CITY OF ALBUQUERQUE

January 16, 2015

**Re: Mile High Little League Improvements
Grading Plan Engineer's Date 1-8-15 (K21D002A)**

MILE HIGH LITTLE LEAGUE SITE IMPROVEMENTS
DRAINAGE AND GRADING PLAN - SOUTH

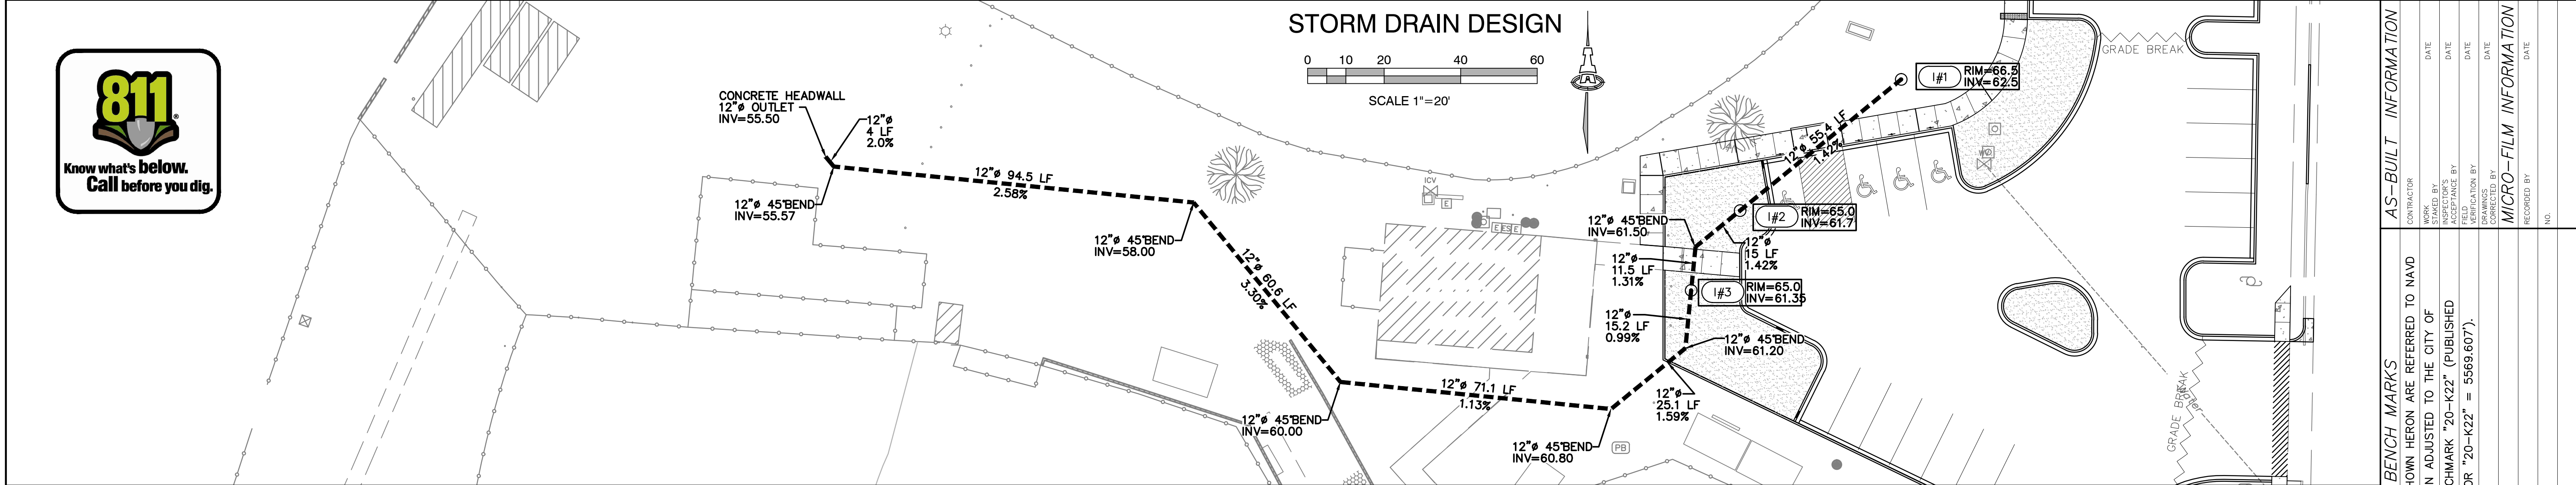
1. On Sheet 5, many of the keyed notes are shifted and pointing to the wrong location.
2. Provide details for the concrete "u" shaped channel and cutoff wall.
3. Provide calculations demonstrating the "u" shaped channel and the 2 foot wide curb opening at elevation 62.0 are sufficiently sized.
4. Next to the ponds, provide the volume.
